**App no: 21.1263**

**Address: Land adjacent to 115 Kemple View Clitheroe**

**Proposal: Proposed construction of two new detached dwellings.**

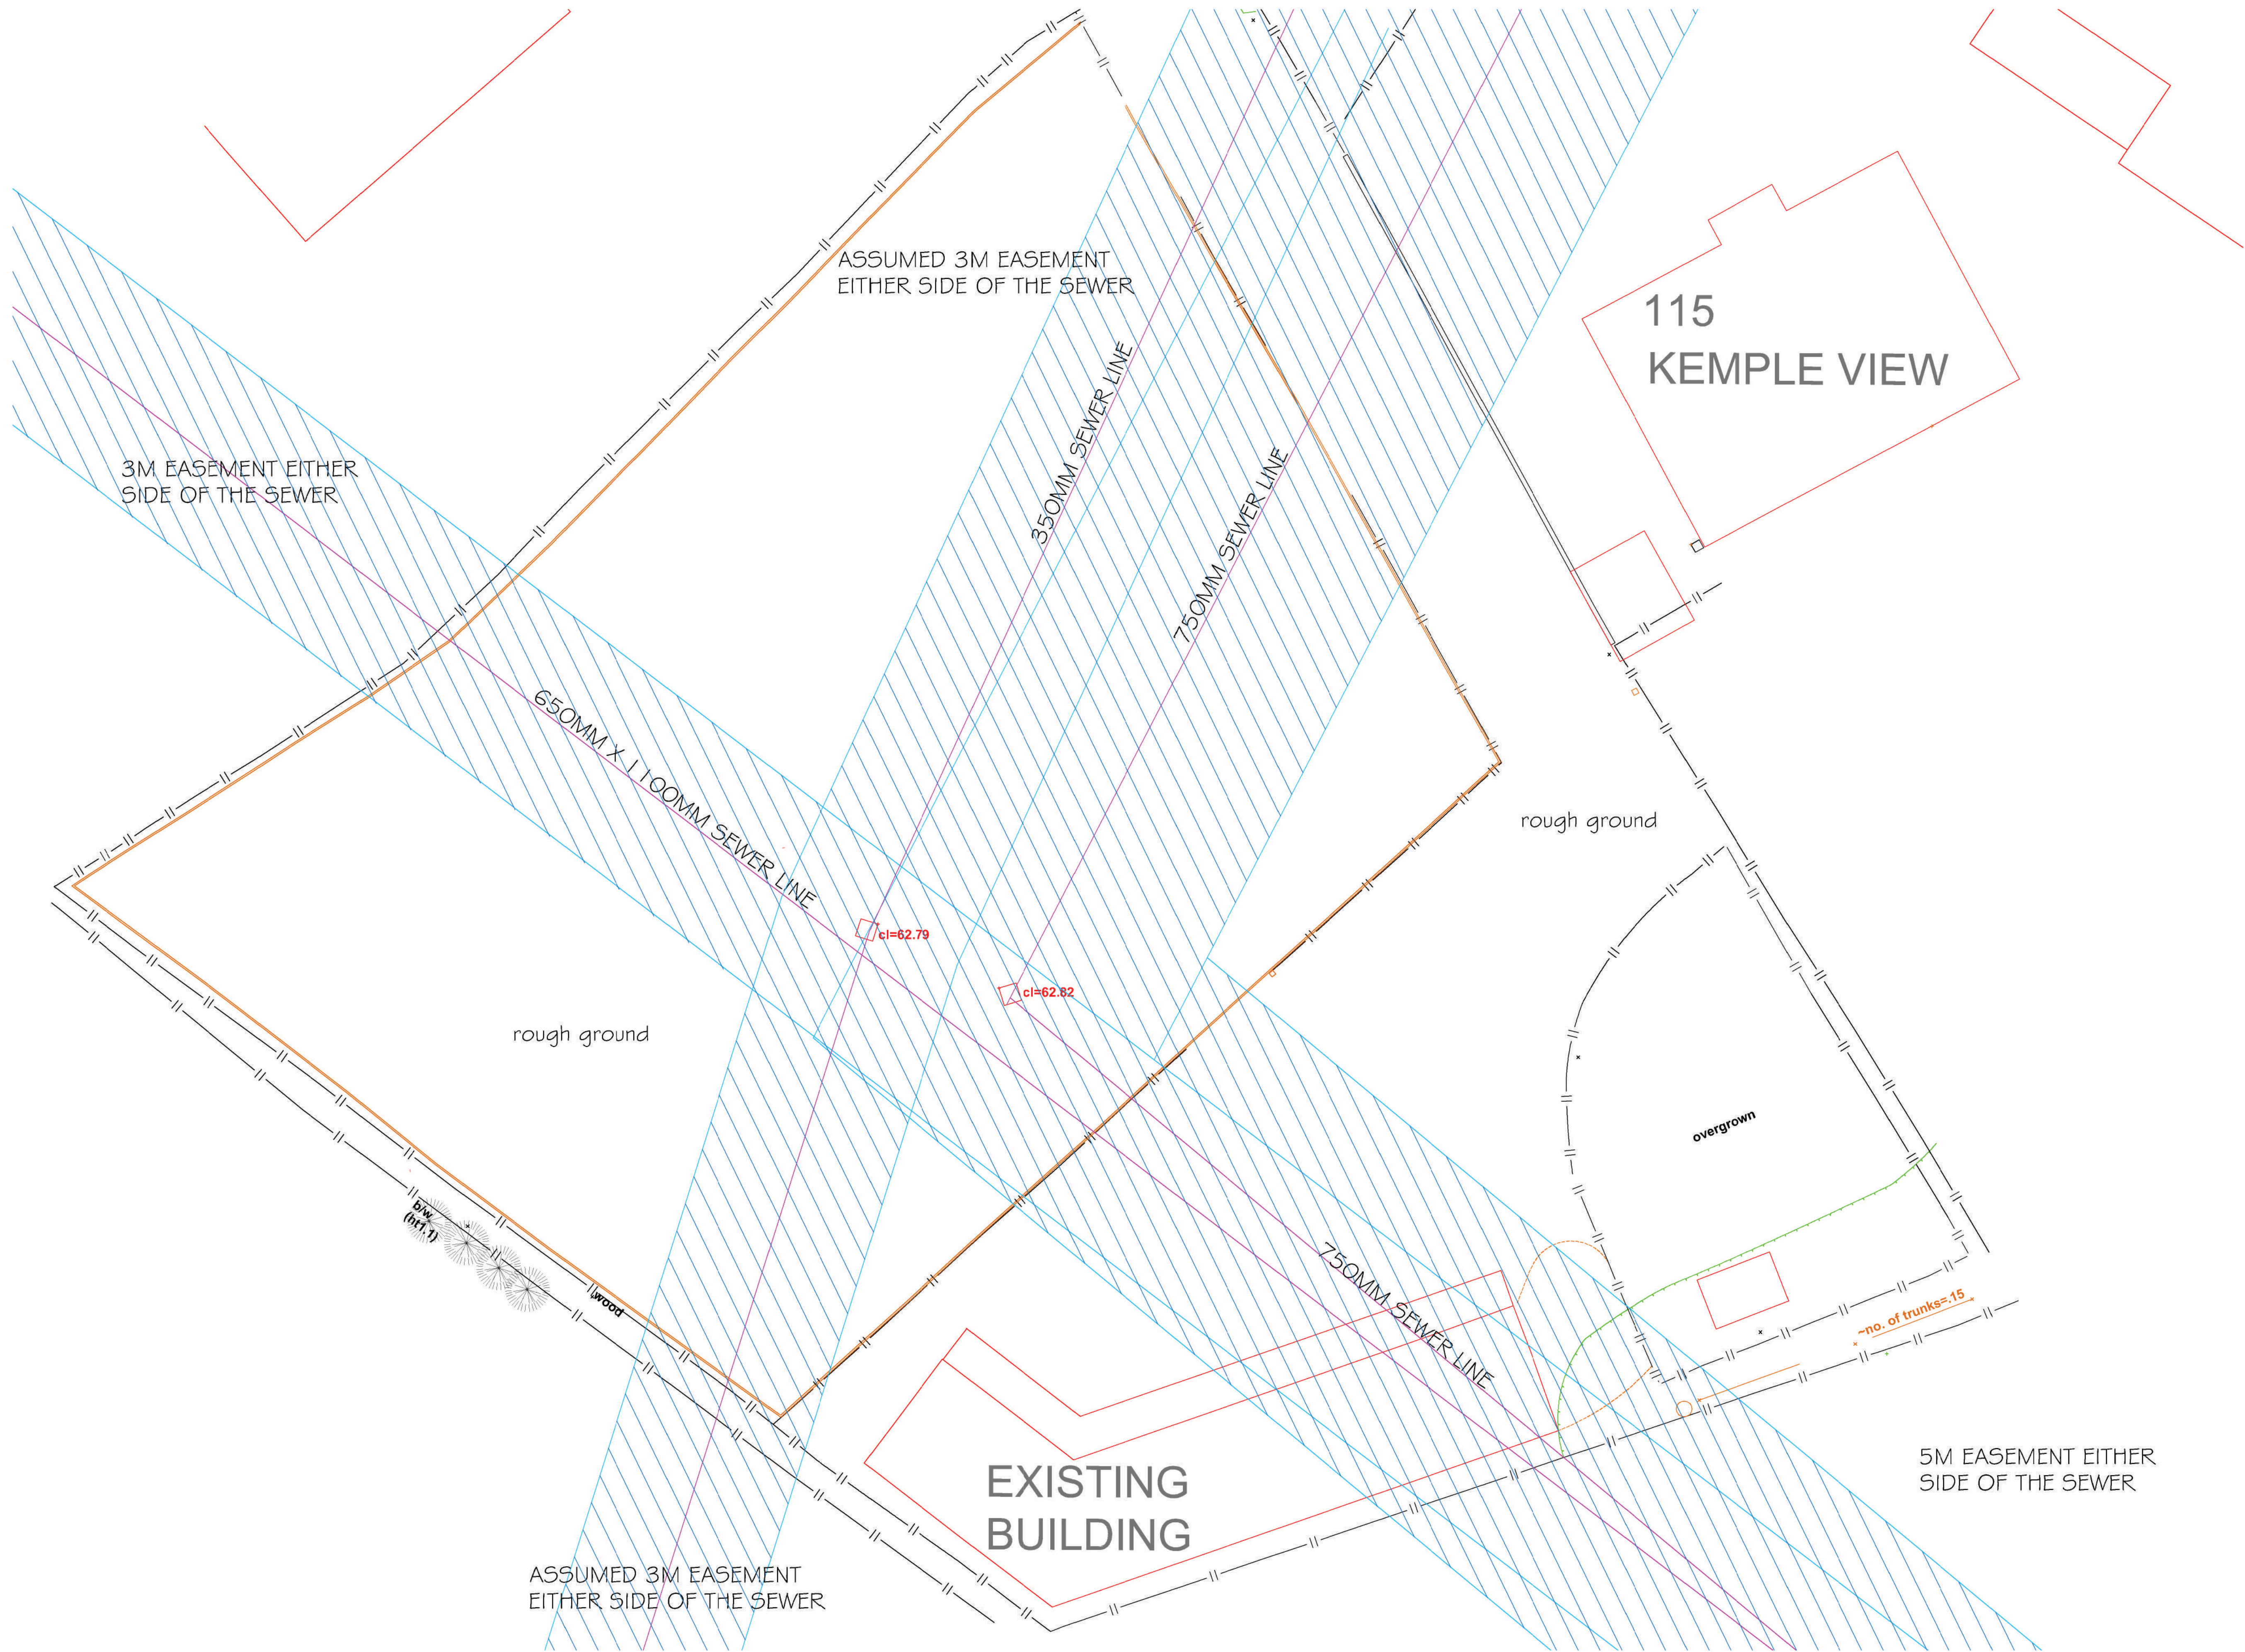
The proposed highway drain diversion shown on drawing 'Site drainage diversion and proposed building outline' PHA/366-100 is acceptable.

2. Prior to commencement of any building works, the drainage diversion works shown on drawing 'Site drainage diversion and proposed building outline' PHA/366-100 shall be completed in accordance with Lancashire County Council Specification under an appropriate agreement with access right s agreed thereafter.
